CITY OF ALBUQUERQUE

Re: Mata Auto Garage
142 40th St SW
30-Day Temporary Certificate of Occupancy
Transportation Development Final Inspection
Architect's Stamp dated 03-03-23 (K12-D037)
Certification dated 12-19-24

SHEET TITLE:
ARCHITECTURAL SITE PLAN

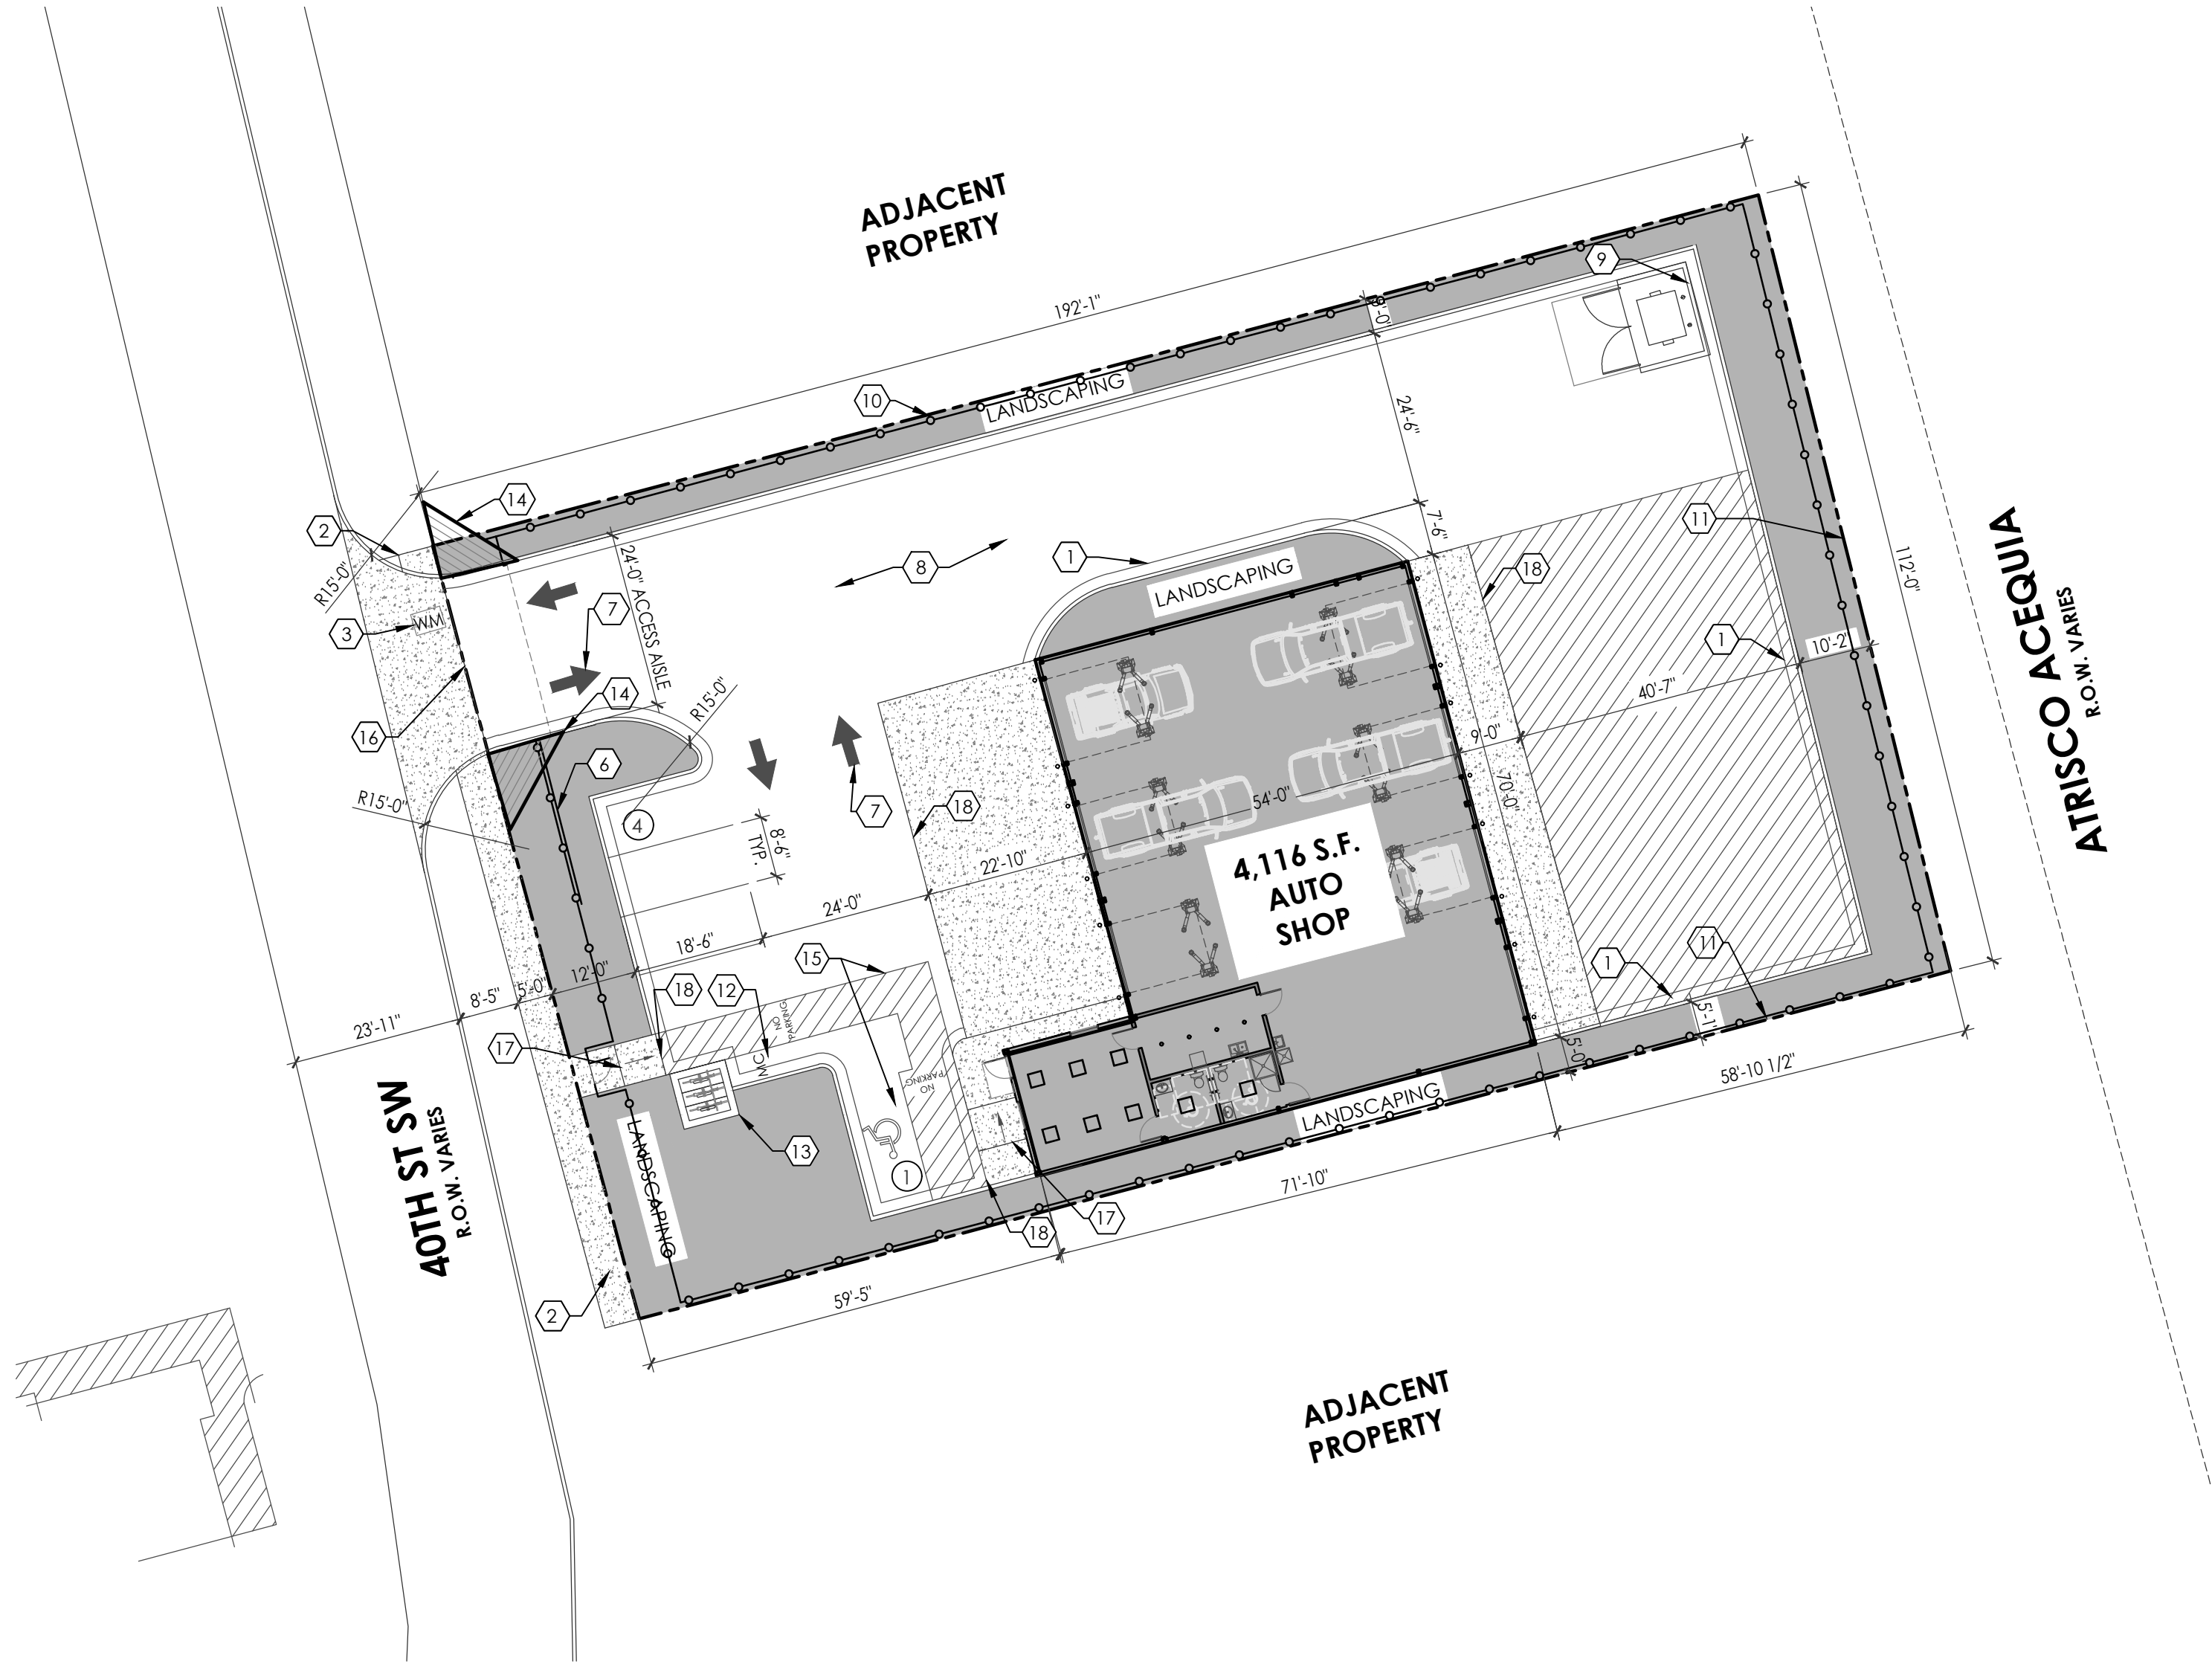
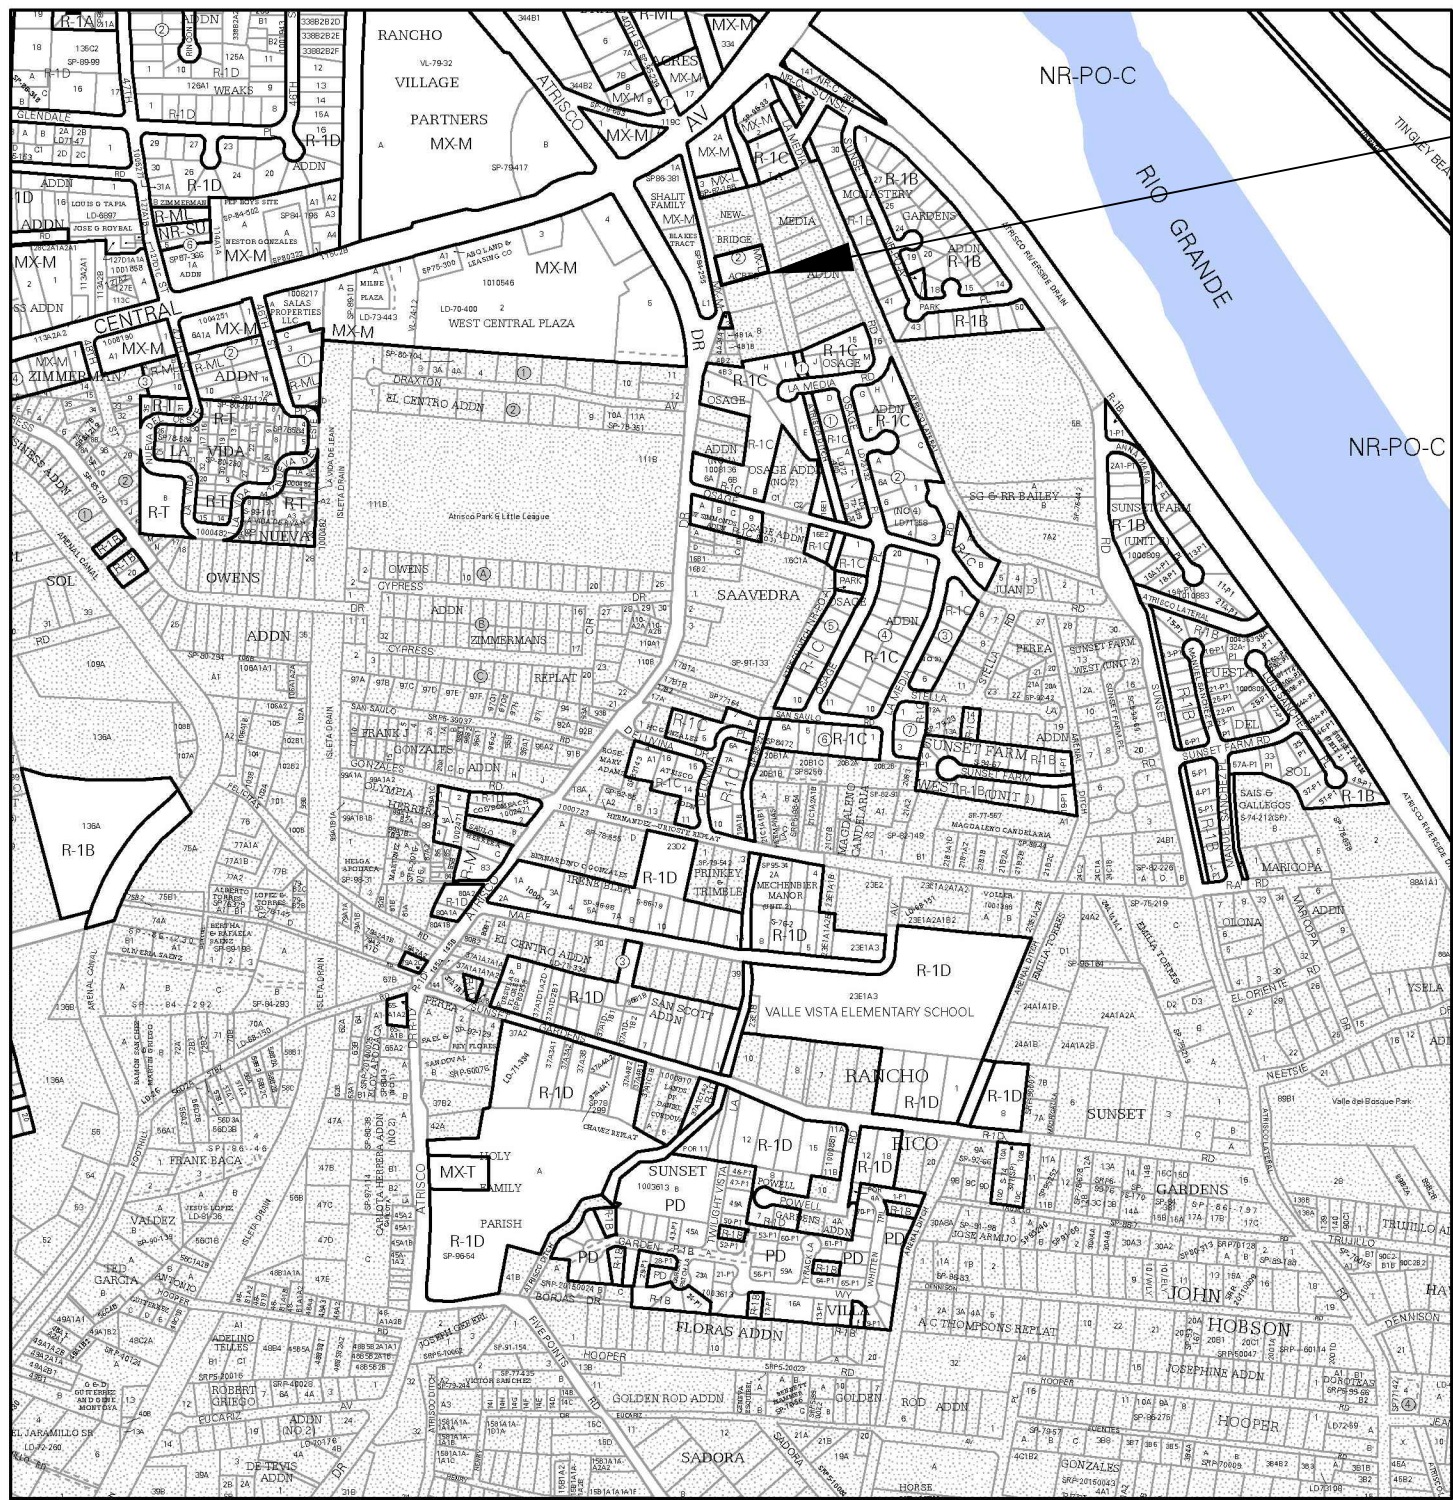
- Per city requirement and approved site plan, a concrete site access must be constructed up to the property line. The current gravel site access may damage the asphalt edge within the city right of way.

- The ADA accessible parking sign must have the required language per 66-7-352.4C NMSA 1978 **"Violators Are Subject to a Fine and/or Towing."** Please call out detail and location of signs.
- The ADA access aisles shall have the words **"NO PARKING"** in capital letters, each of which shall be at least one foot high and at least two inches wide, placed at the rear of the parking space so as to be close to where an adjacent vehicle's rear tire would be placed. (66-1-4.1.B NMSA 1978)

- Per previous emails, the construction of the sidewalk and curb and gutter will be postponed until the adjacent south east property begins constructing their sidewalk and curb and gutter.
